Please ask for: Nicola Moore
Email: nicola.moore@arun.gov.uk
Telephone: Ext 37944
Our Ref: FP/7/22/T
Your Ref:
Date: 19th January 2022

Application for Works to Trees(s) subject to a Tree Preservation Order(TPO)

Location: 8 South Road Felpham PO22 8EF

BEACH ESTATE

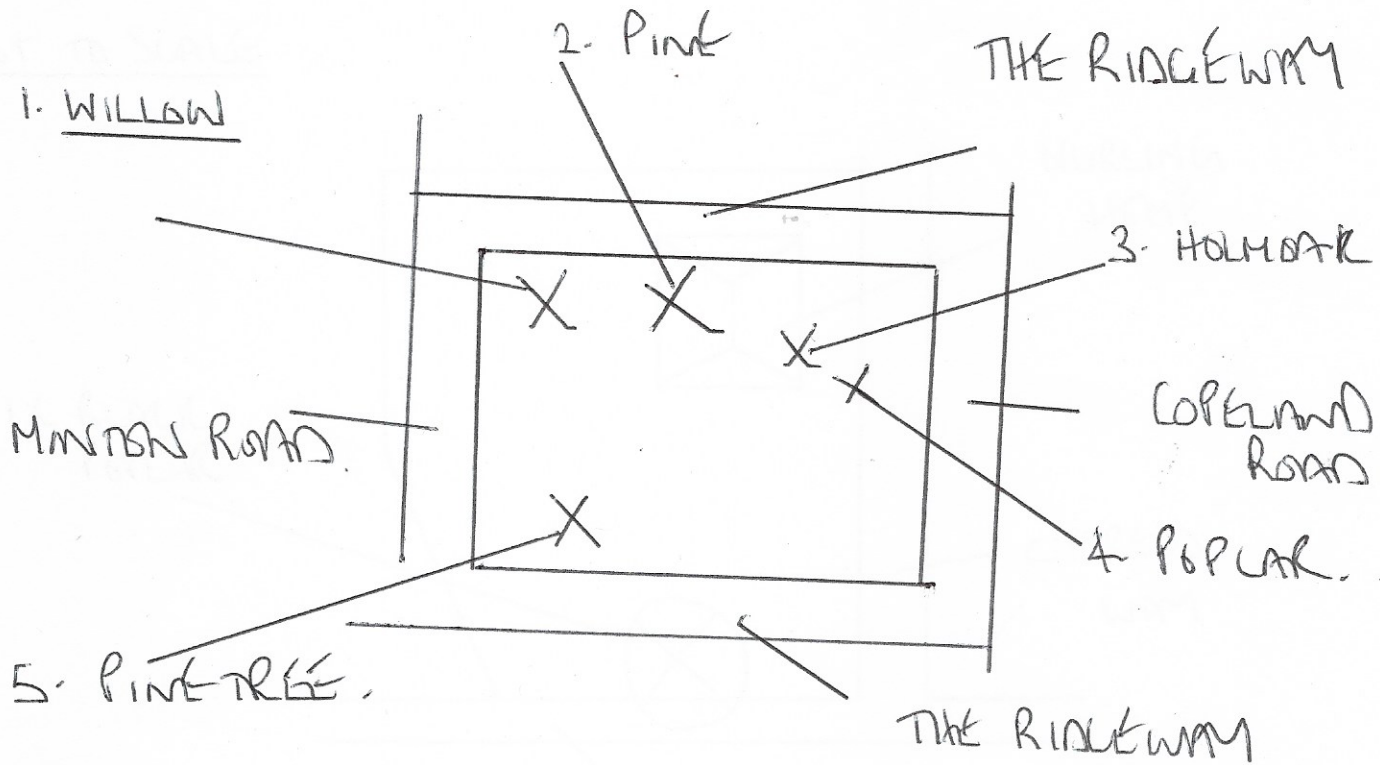
Please confirm the location of the trees as the submitted sketch plan include The Ridgeway, Copeland Road and Minton Road, but on checking our map these are not road near to 8 South Road.
